Consultation response from KC PROW (footpaths)

2025/90655 – The Priory, Whitechapel Road, Cleckheaton

Demolition of existing pub and erection of a new two storey building comprising 8 self-contained supported living flats with ancillary staff facilities, single storey summer house and other associated works

Date Responded : 8/5/25

DRAFT SECTIONS

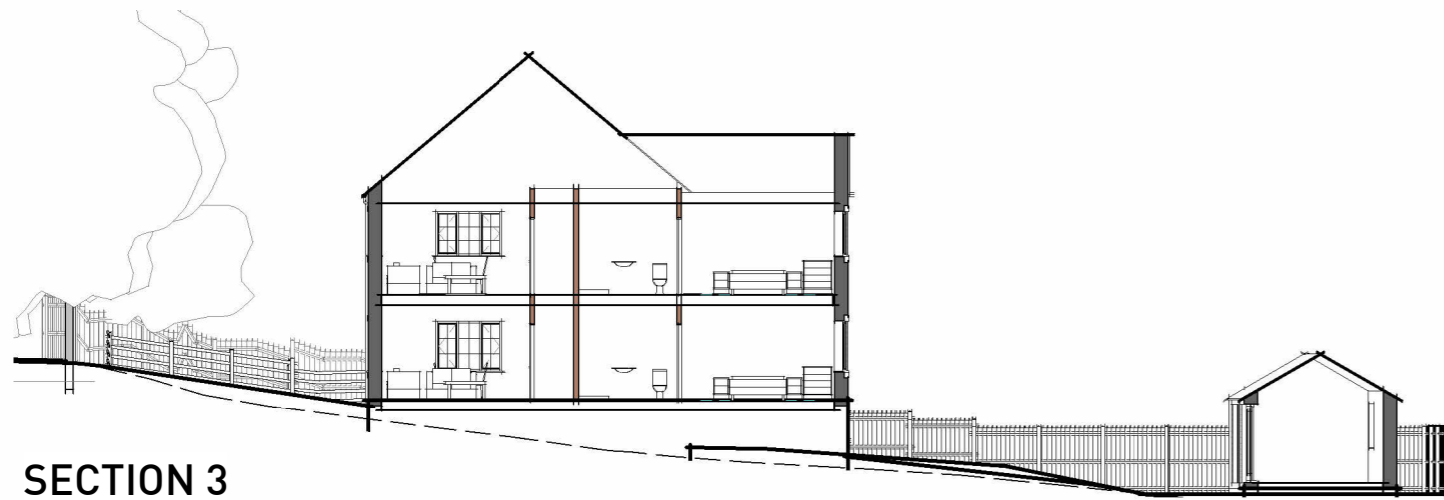
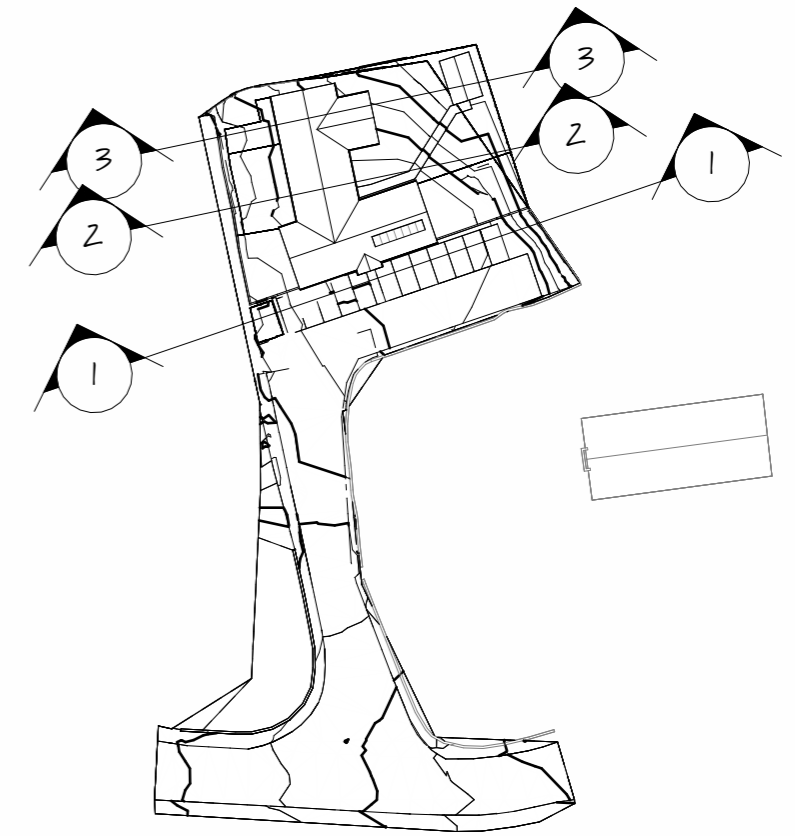
The sections do not show the footpath even though the section includes where the footpath is. Prow would also need details of the boundary of the development and details of the width of path to be provided, surfacing and how the path is to be maintained during the construction.
